Recommendation Report for Planning Permission for Works or Extension to a Dwelling

REF NO: FP/233/20/HH

LOCATION: 9 Wansford Way
Felpham
PO22 7NL

PROPOSAL: Single storey rear extension, first floor side extension and conversion of roofspace to habitable use and dormer.

Proposed East Elevation

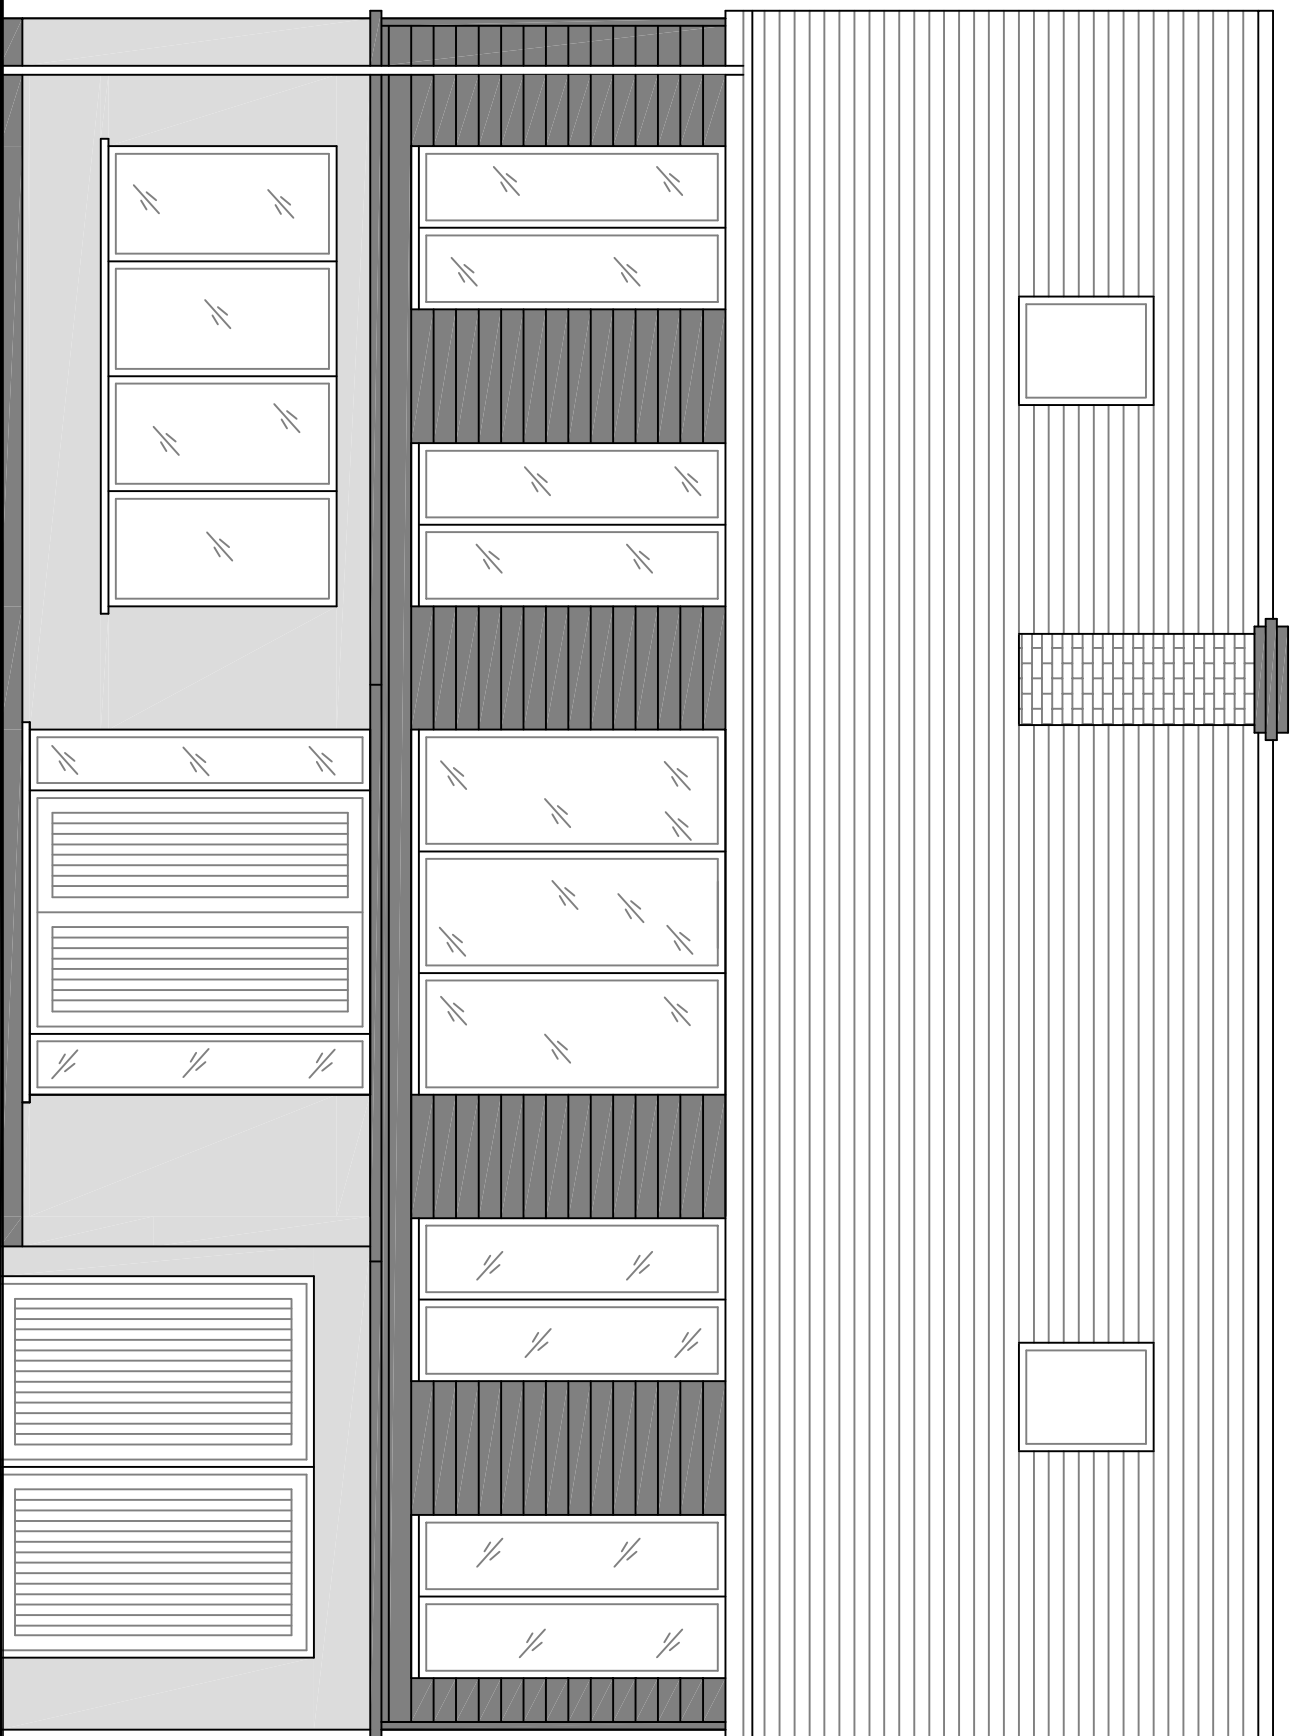
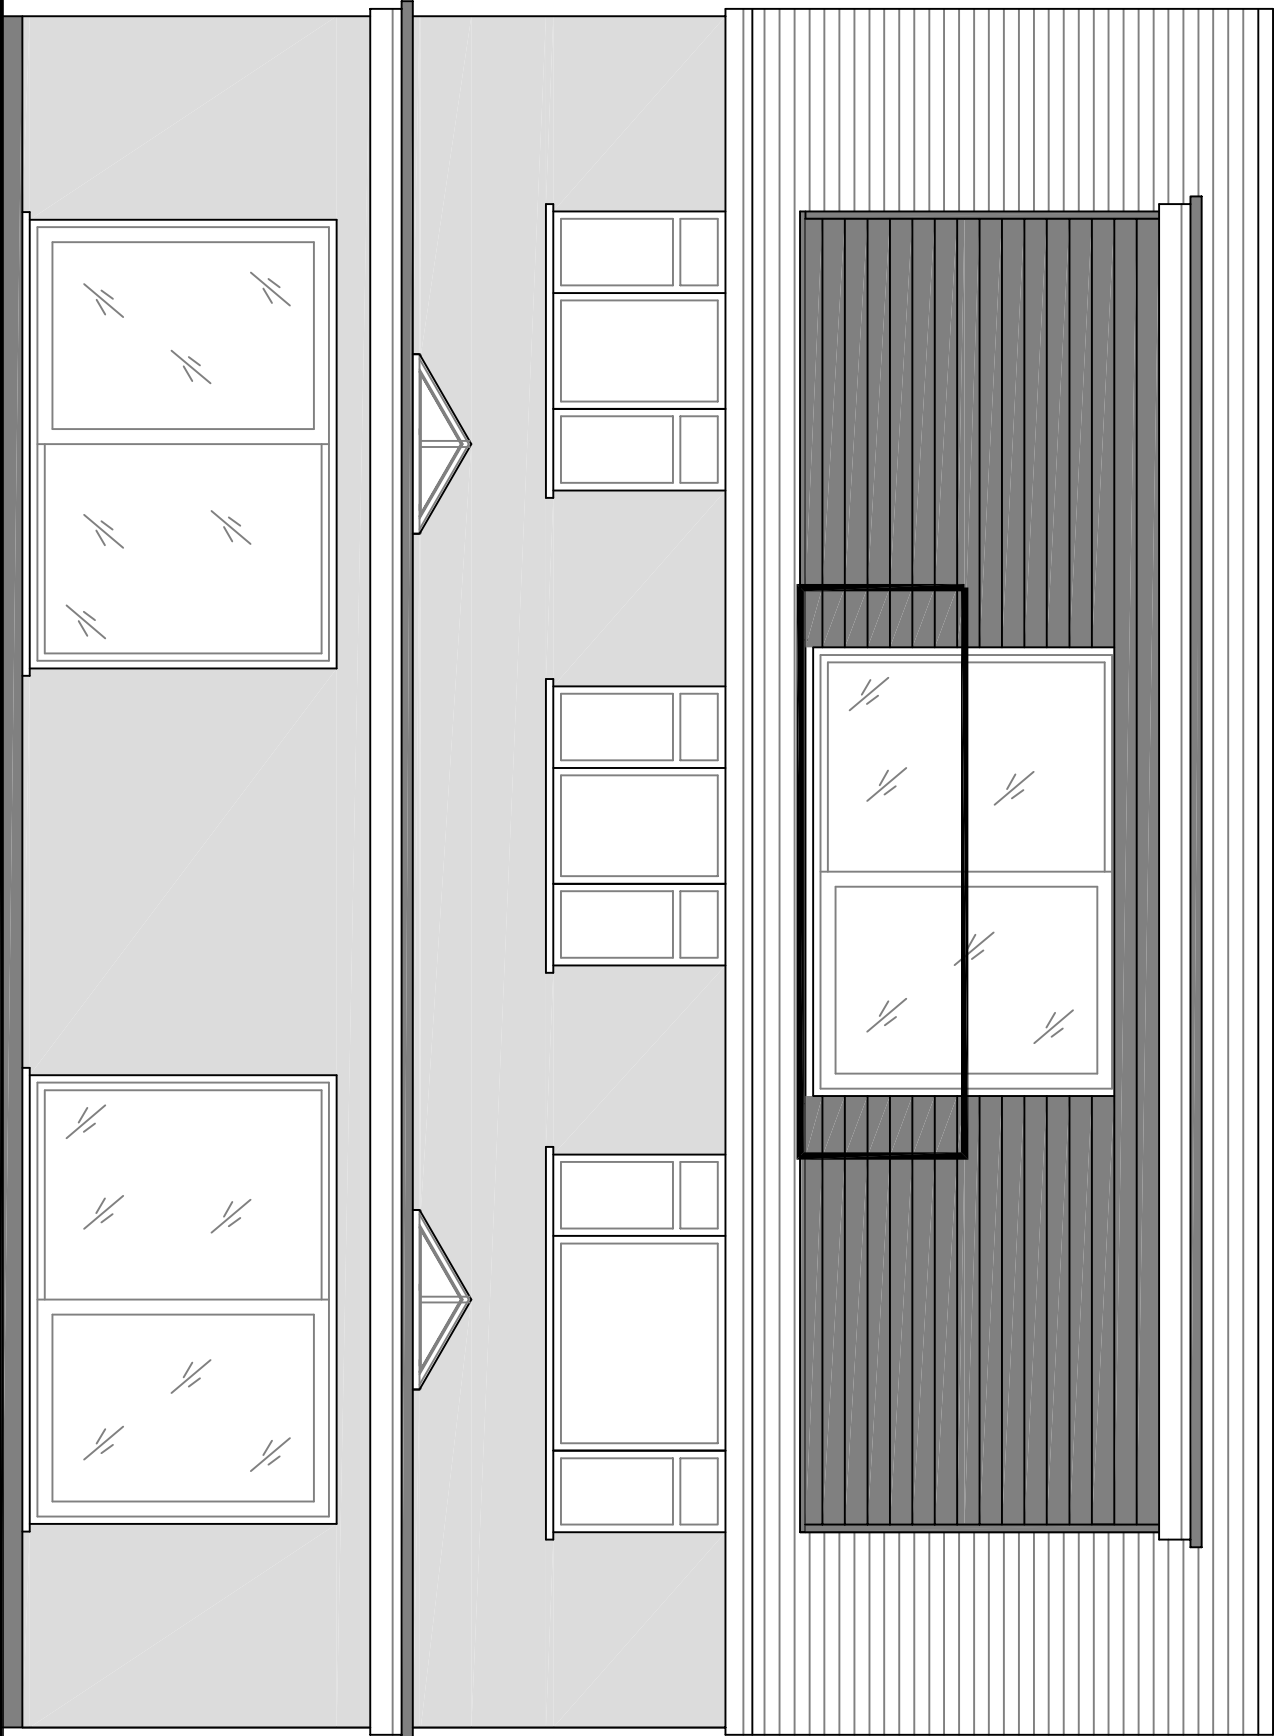
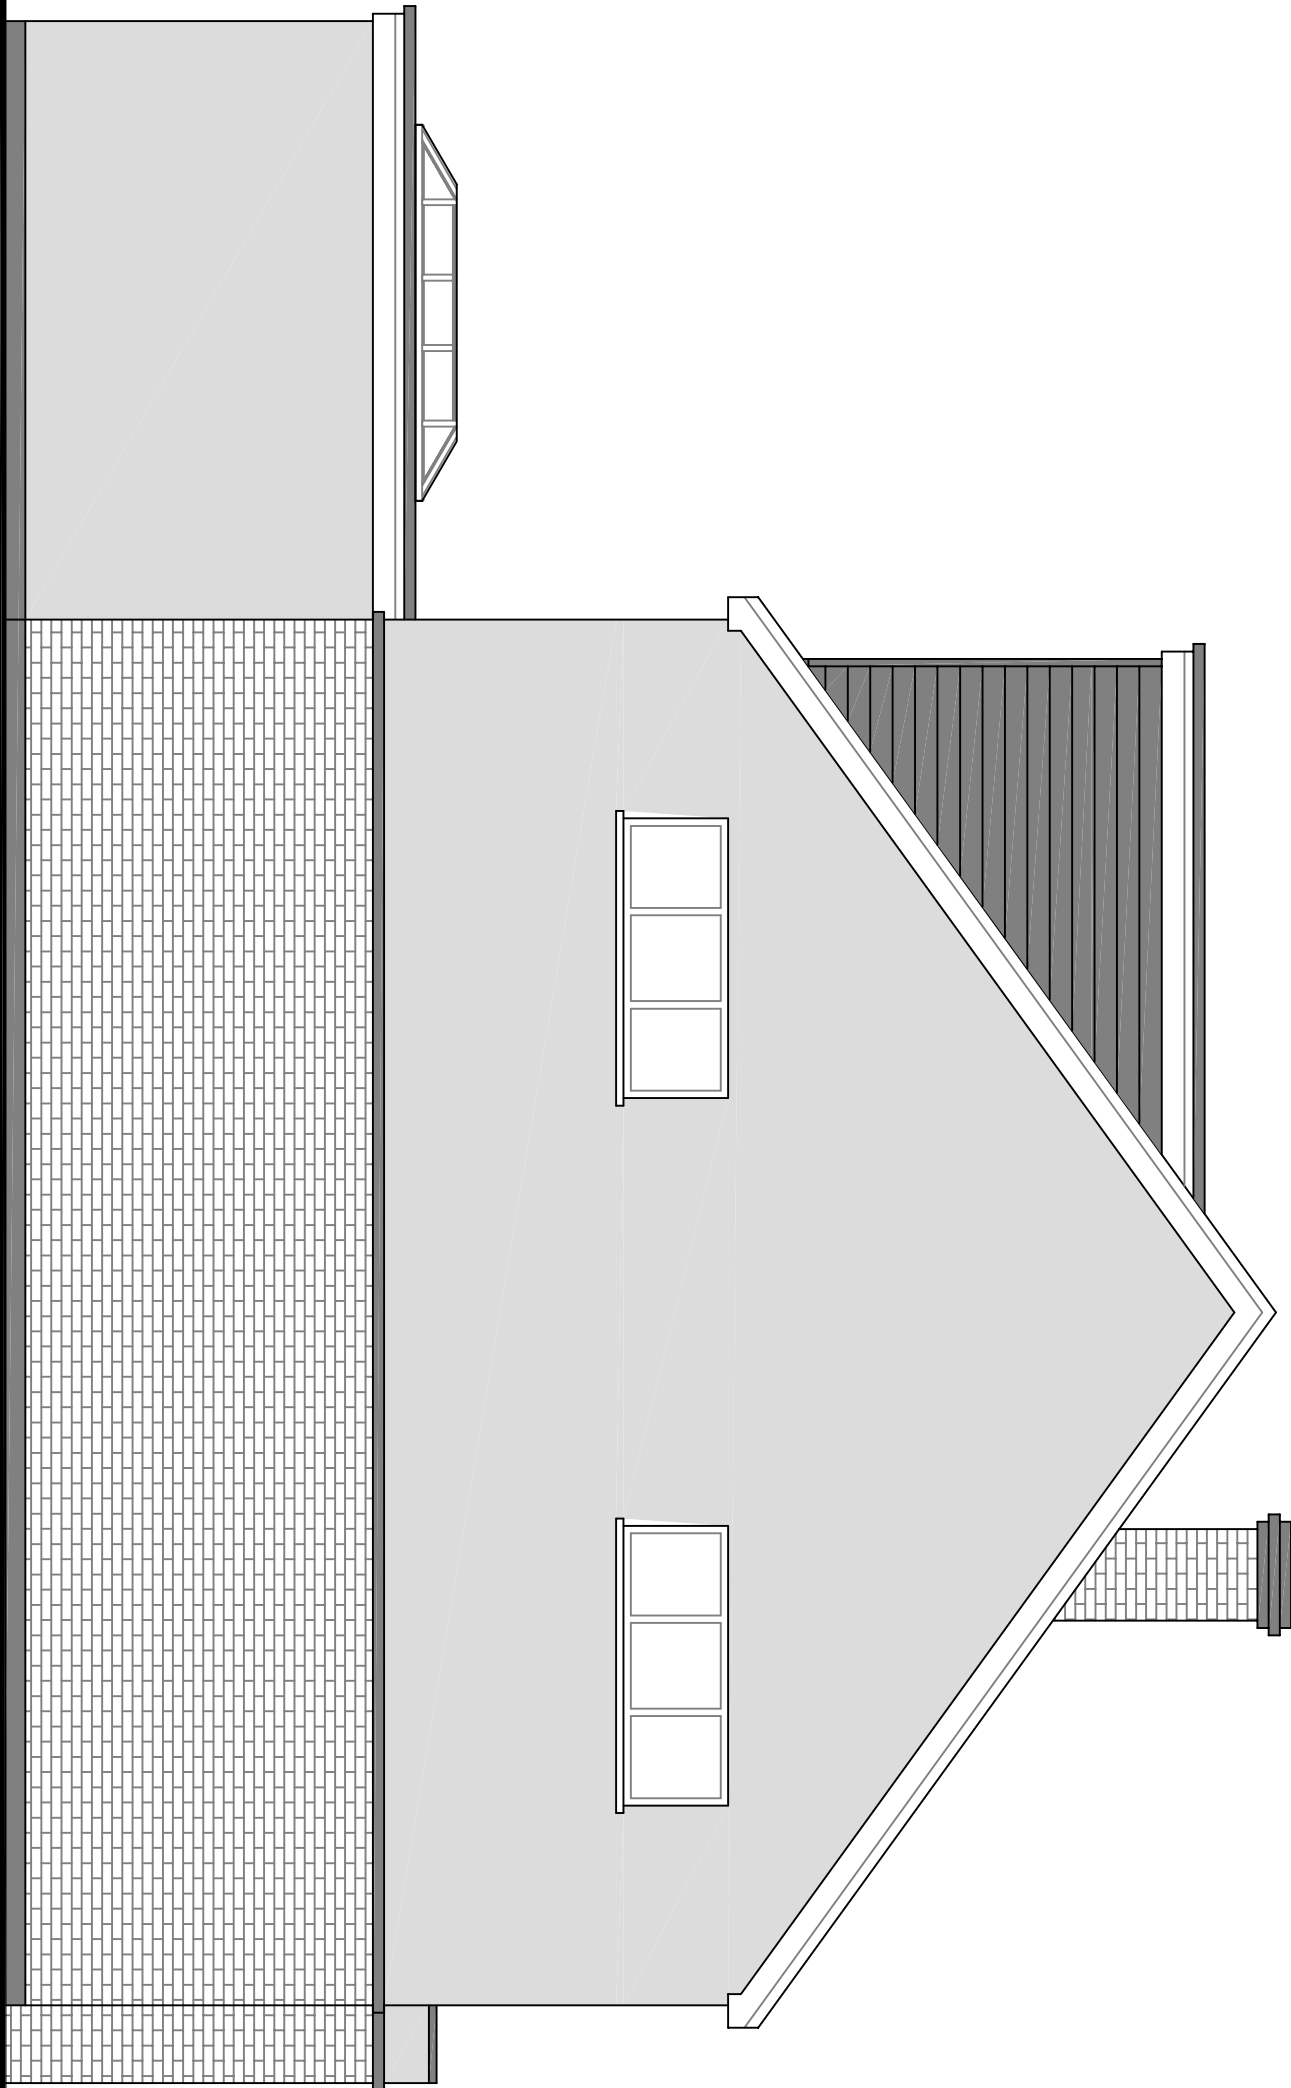
The property has an attached garage to the northern side and a first floor will be constructed above. The roof will extend to encompass the first floor addition and as such it appears well integrated and as a subservient addition.

Over 1m is retained to the boundary from the first floor addition and is not considered to appear an overdevelopment on site.

There will also be a dormer to the rear elevation. This will have a depth of 3.6m and a height of 2.6m and will run along the rear roof slope retaining approximately 1.3m to both sides. This will have a juliet balcony again overlooking the rear. Whilst this will give rise to views that aren't currently achievable, although with no properties directly to the rear, views are not considered significant.
